Our Ref: EN010123

Date: 13 March 2023

### **Application by Ecotricity (Heck Fen Solar) Limited for an Order Granting Development Consent for the Heckington Fen Solar Park.**

#### **Advice following issue of decision to accept the application for examination**

LAND AND CROWN LAND PLAN - OVERVIEW PLAN

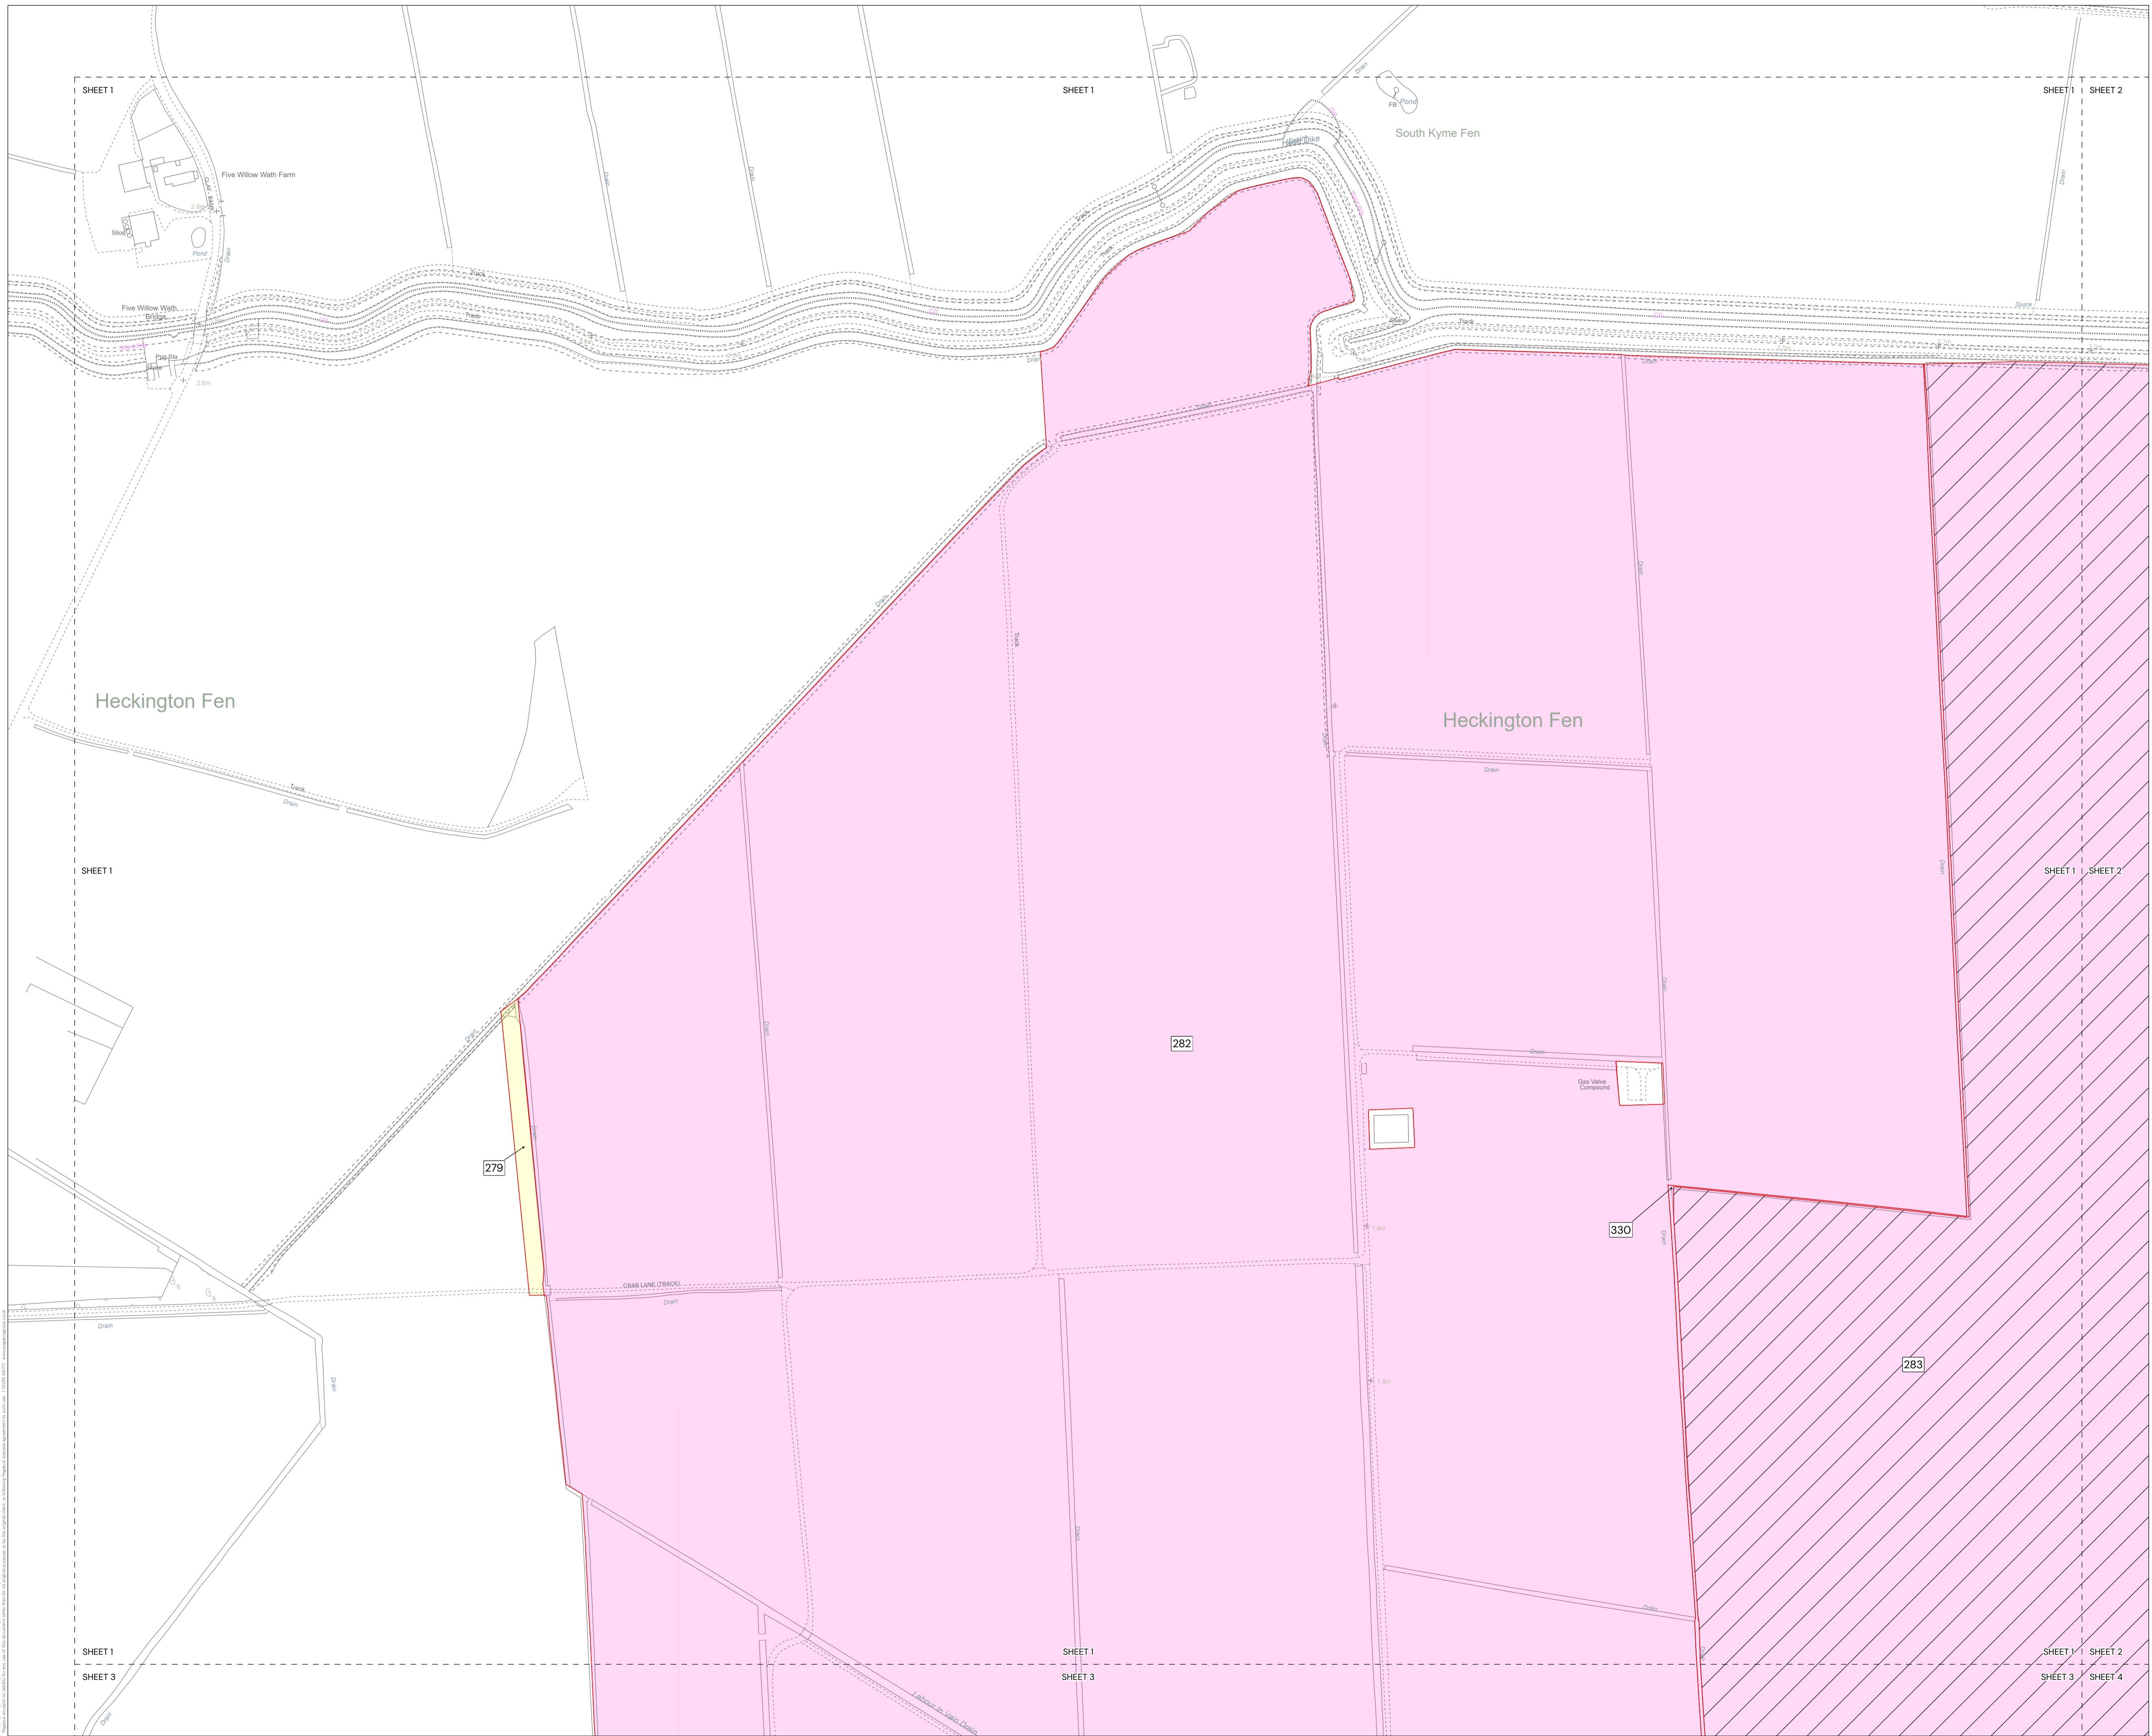
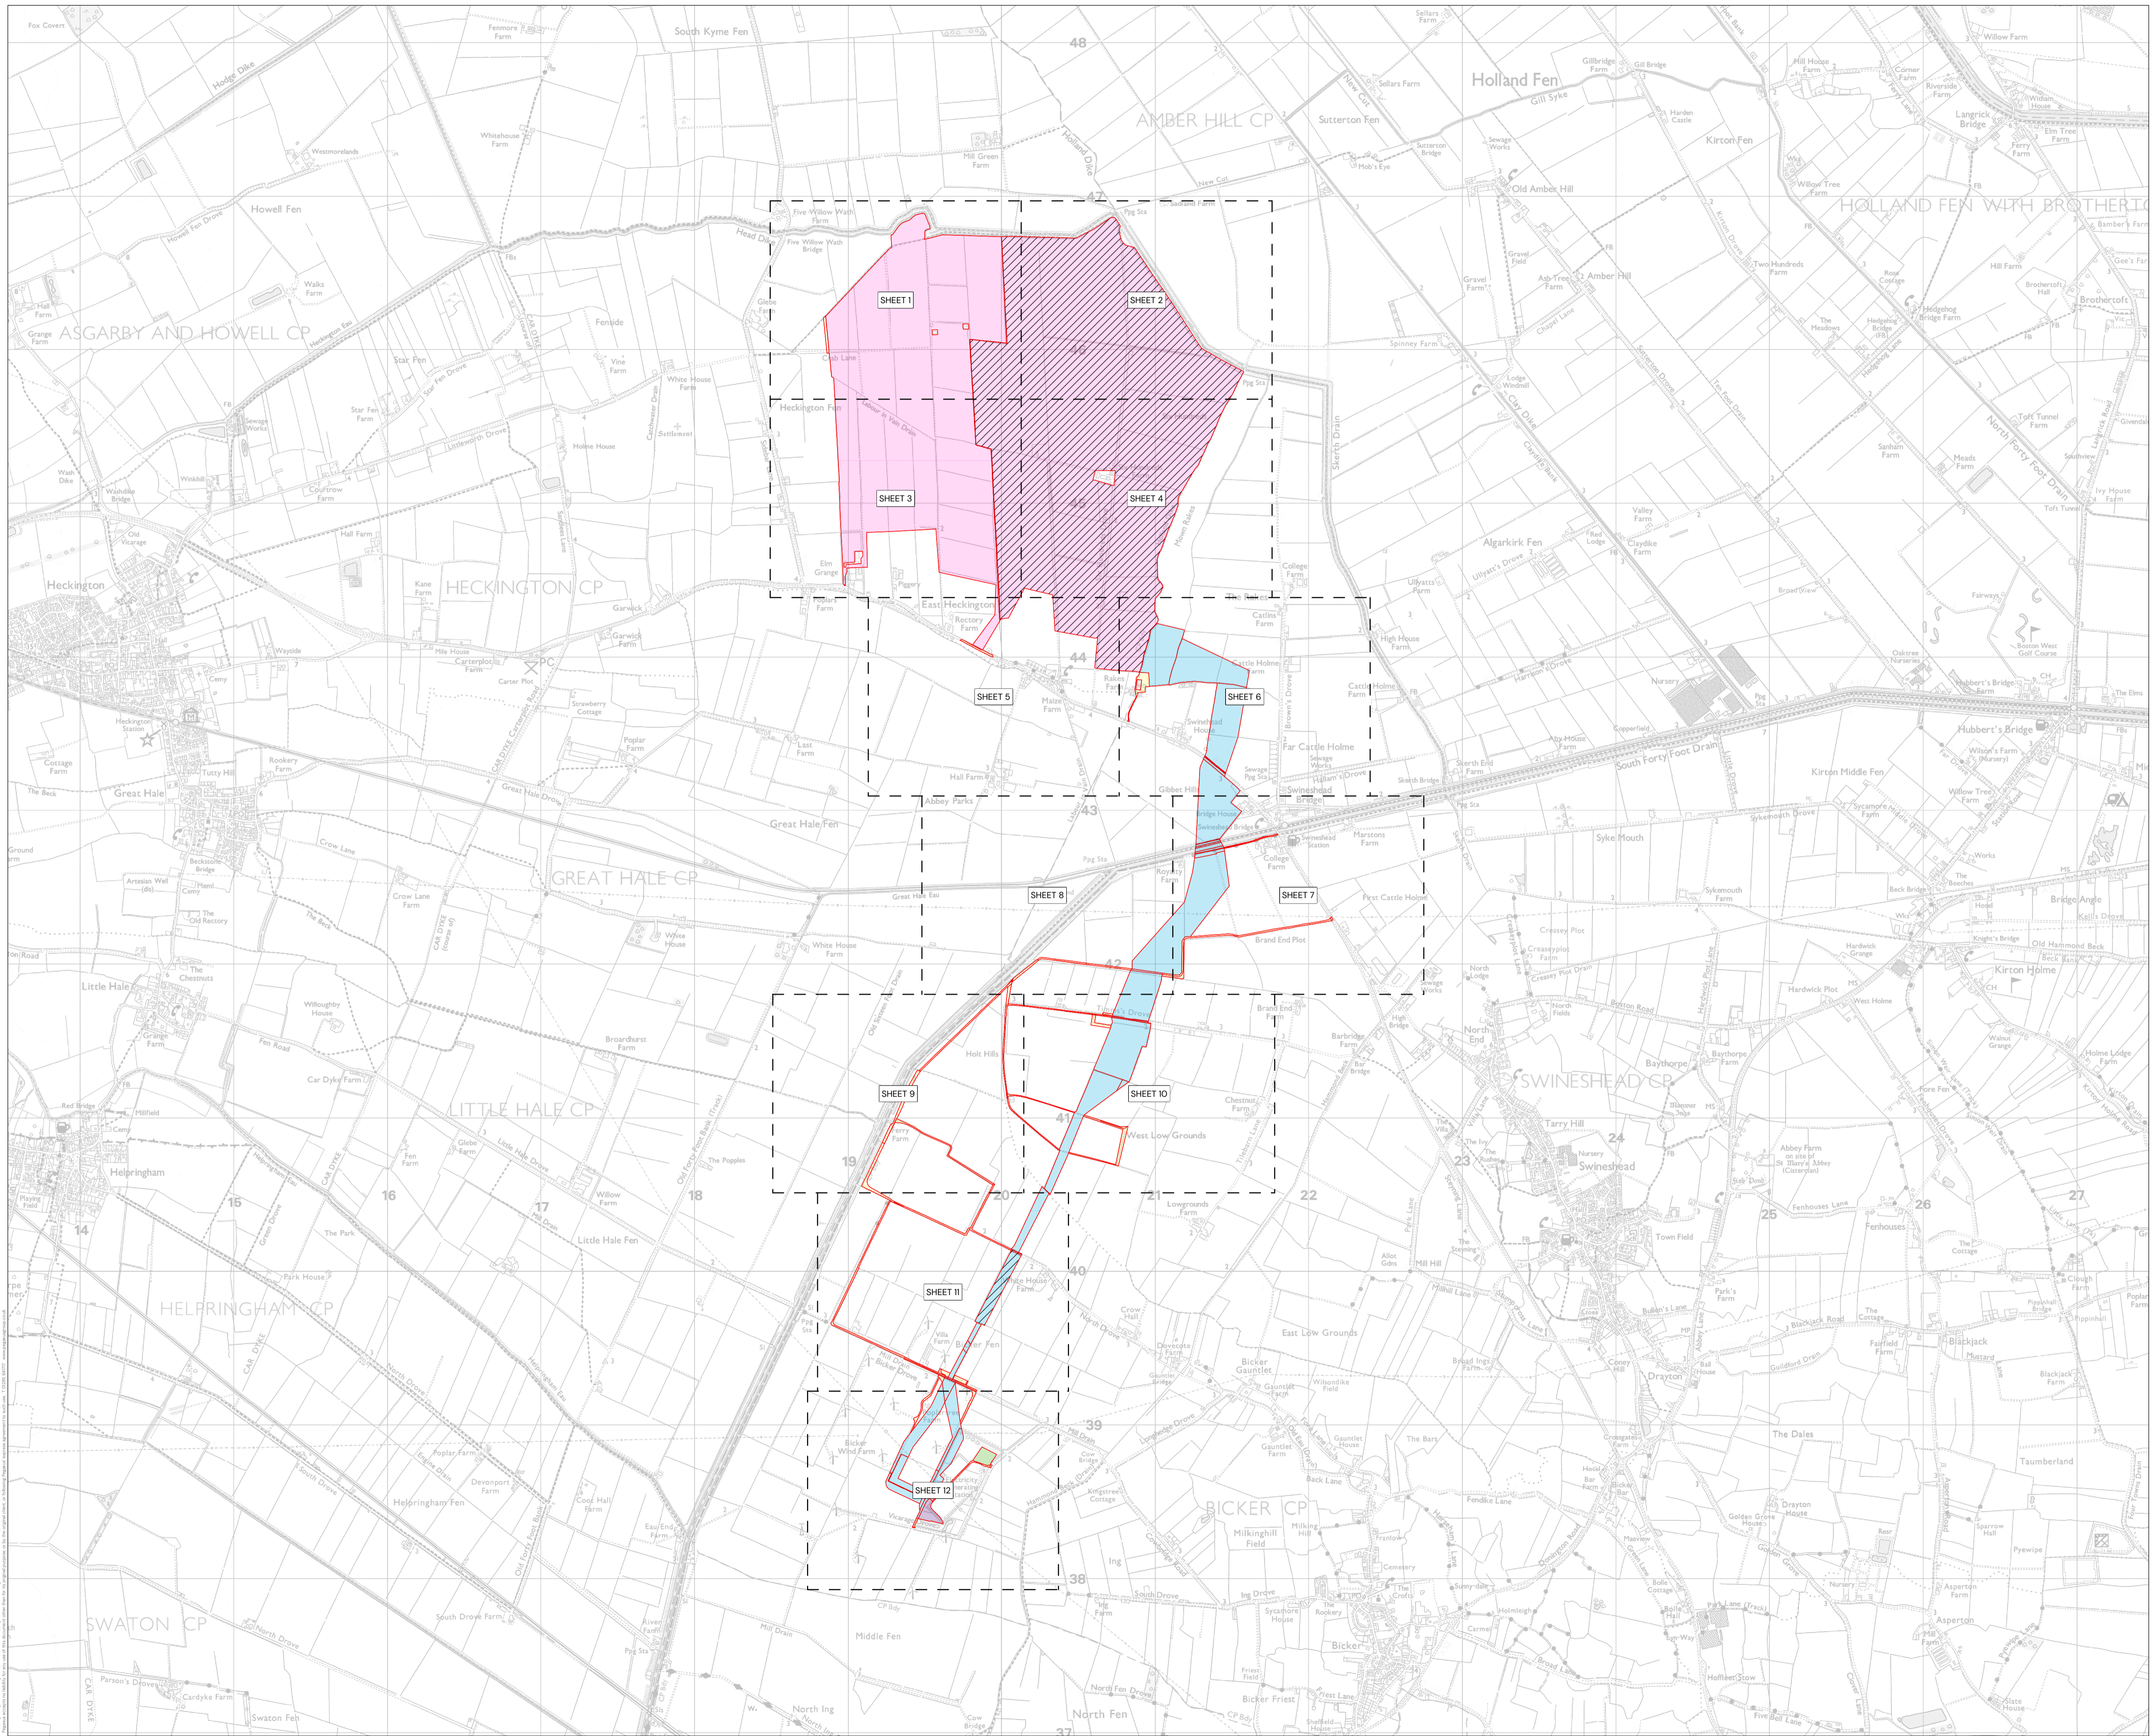
The legend used on the Land and Crown Land Plan is difficult to interpret. The Applicant should clarify the rights sought by cross-referencing to the information contained within the introduction of the Book of Reference to enable easier interpretation.
